**Consultation Response KC Landscape**

<b>Planning Number:</b>	2025/93229		
<b>Proposal:</b>	Discharge of details reserved by conditions 15 (drainage), 33 (waste), 37 (cycle parking), 41 (LEAP) on previous permission 2021/93567 for demolition of existing commercial buildings and erection of 180 dwellings with associated works		
<b>Location:</b>	Land off, Westgate, Cleckheaton, BD19 5DR		
<b>DEVELOPER/APPLICANT/AGENT:</b>	<b>Strata</b>		
<b>Planning Officer:</b>	Farzana Tabasum		
<b>Date Responded:</b>	1.12.25	<b>Responding Officer:</b>	EM
<b>Site Area (Hectares)</b>		<b>Responding Ref:</b>	<b>PP75</b>

**NOTES/COMMENTS: COND 41 LEAP:**

SHEET TITLE: **LEAP**

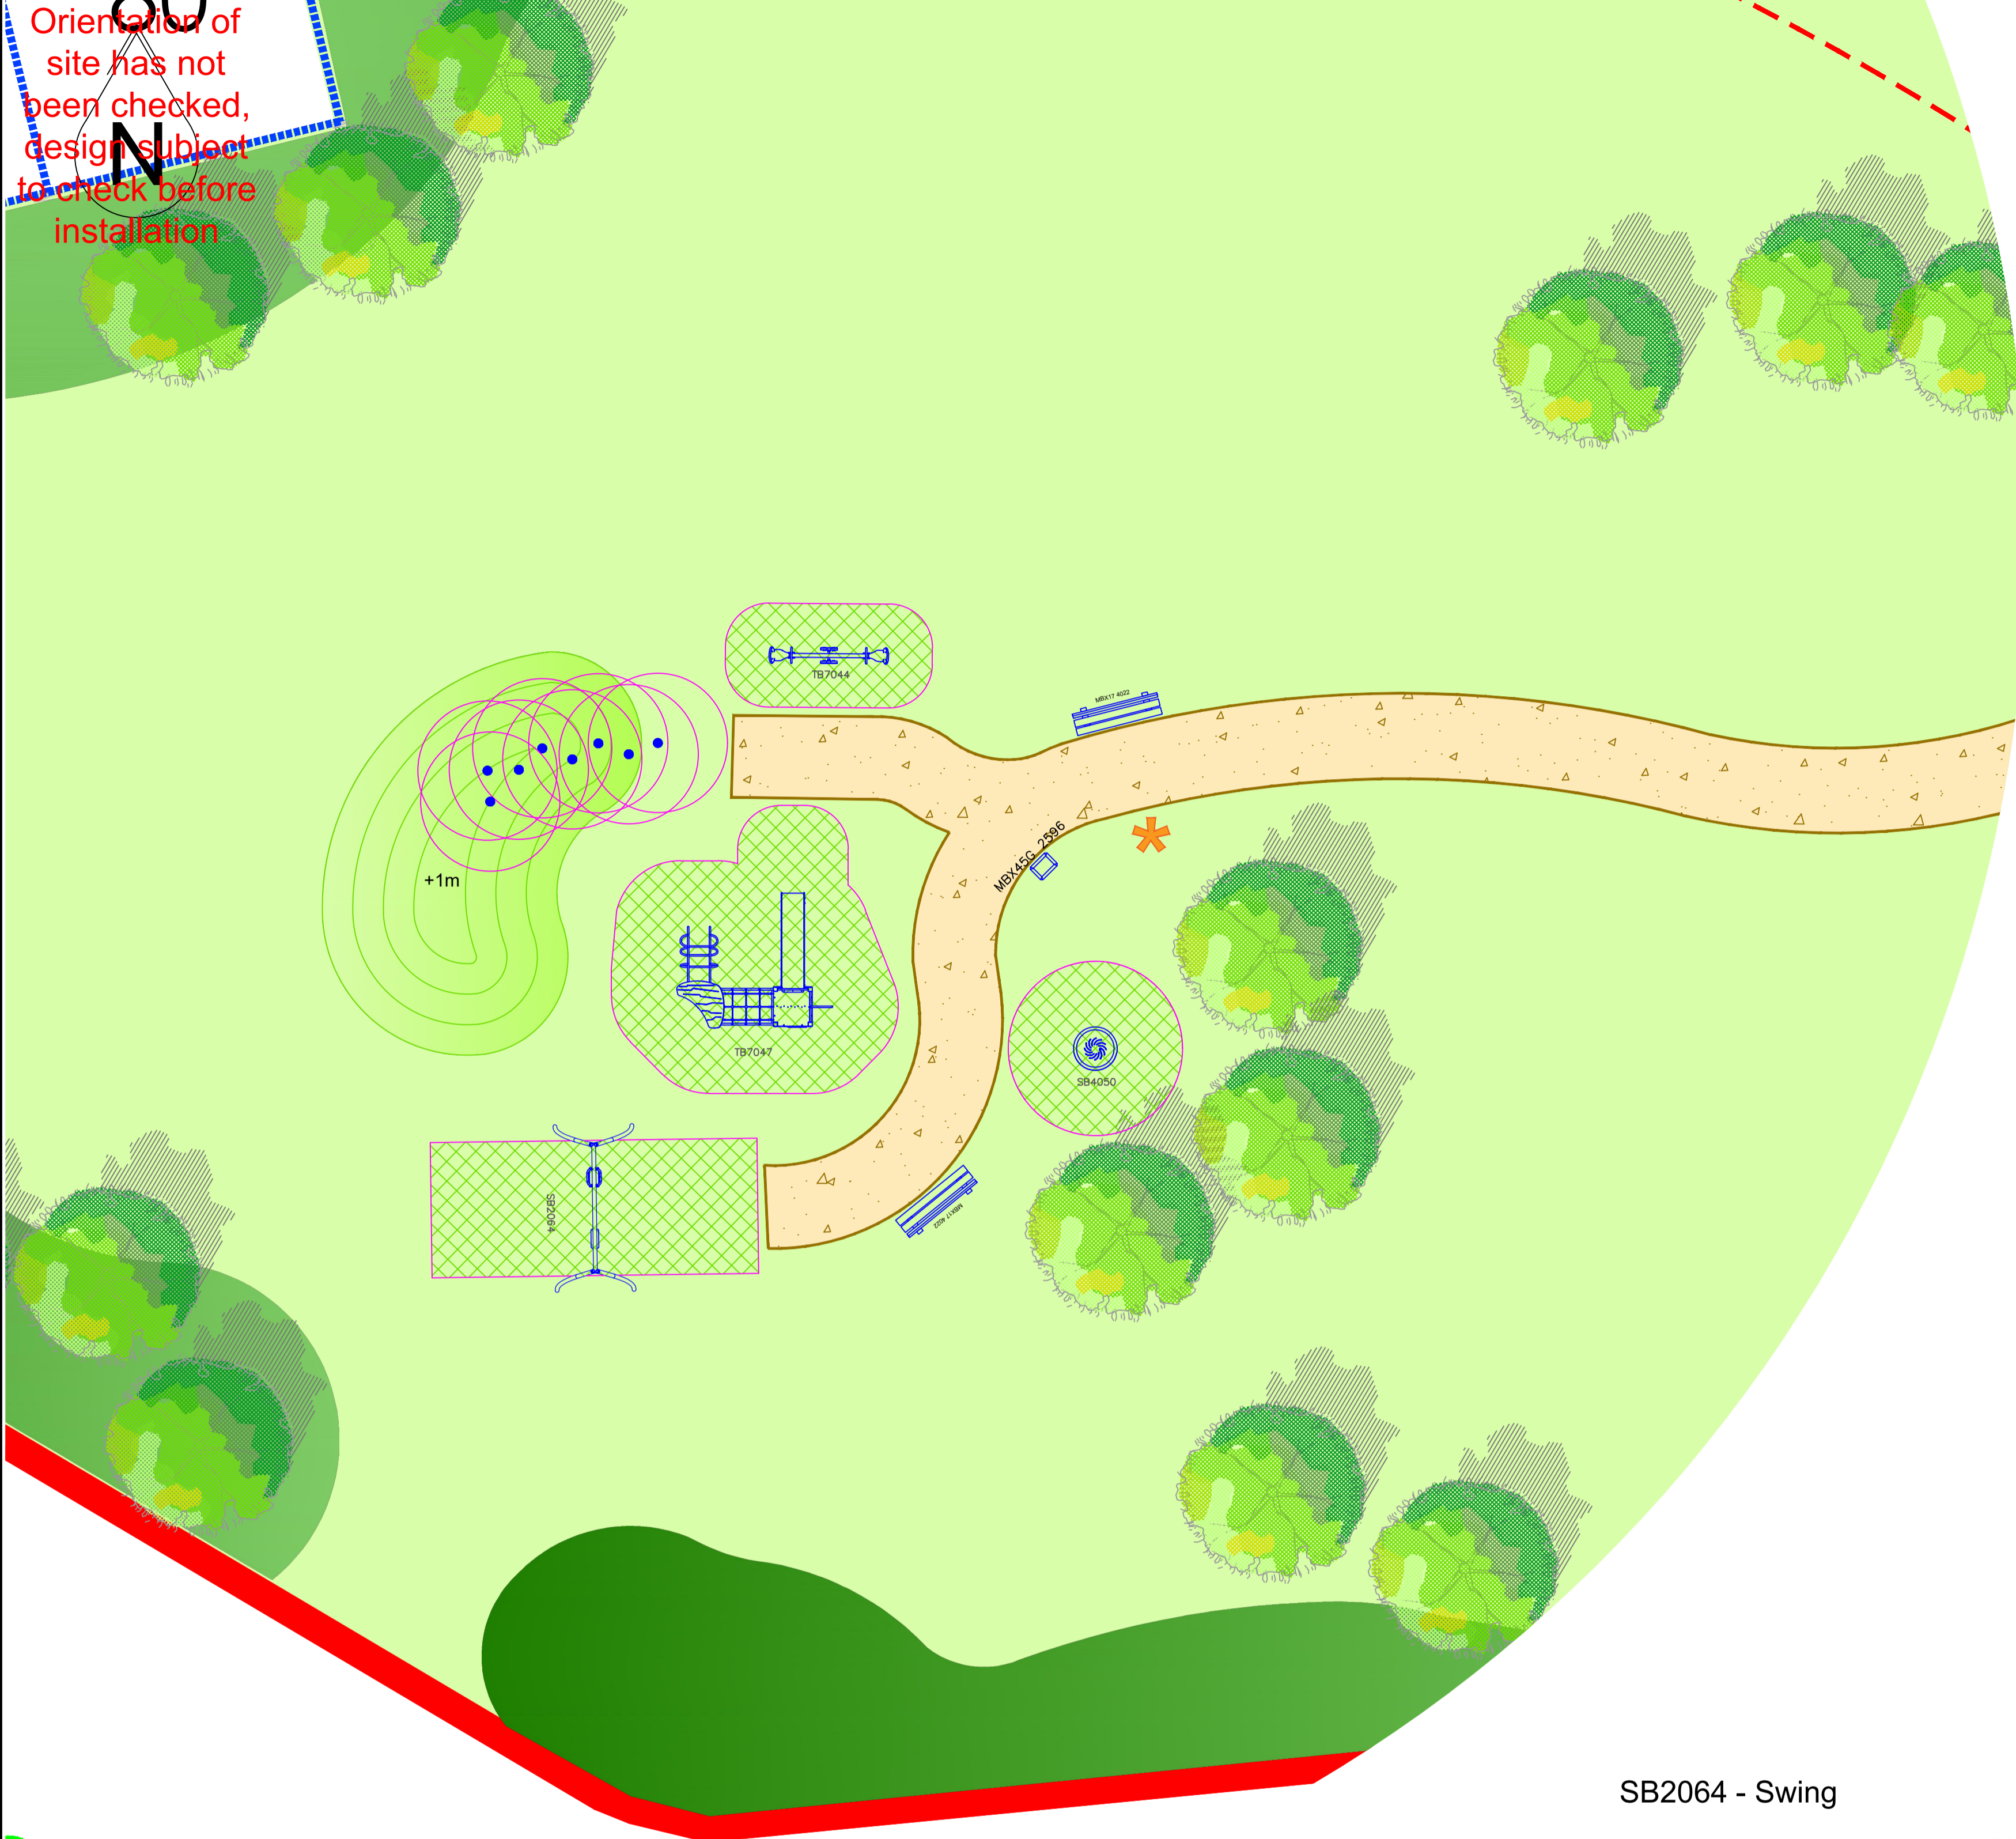
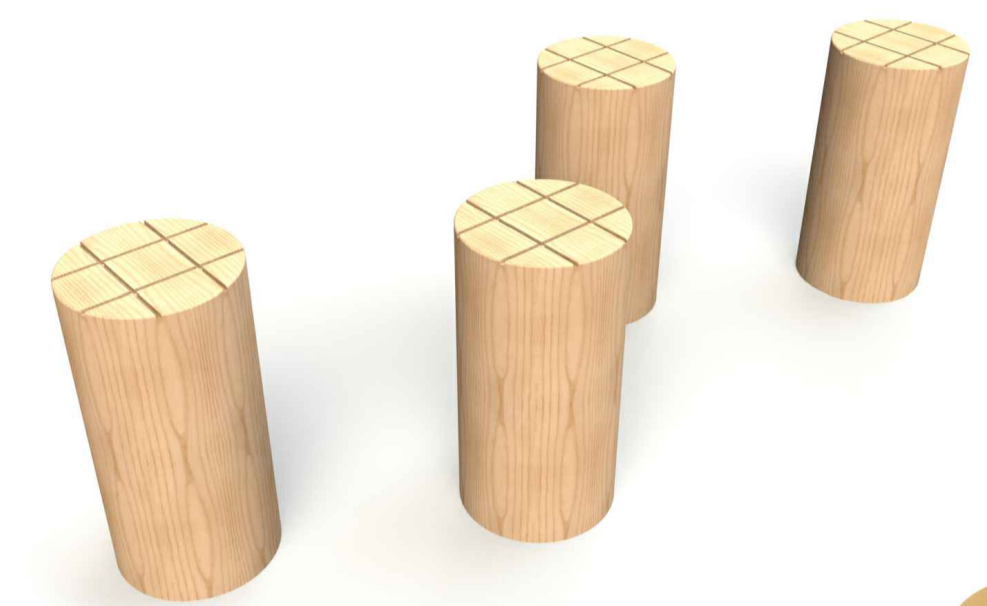
Aside from our ongoing concern about the slide orientation, specifically the north-facing slides, (which are more prone to dew, frost, and slower drying) it looks like they have acknowledged and addressed the other points we raised.

1. If the climbing frame unit were pivoted clockwise 90 degrees to face east (rather than north), both the slides would benefit from early sun exposure from the east, helping them dry out sooner without their metal surfaces overheating in the midday or afternoon sun (so don't face them south).
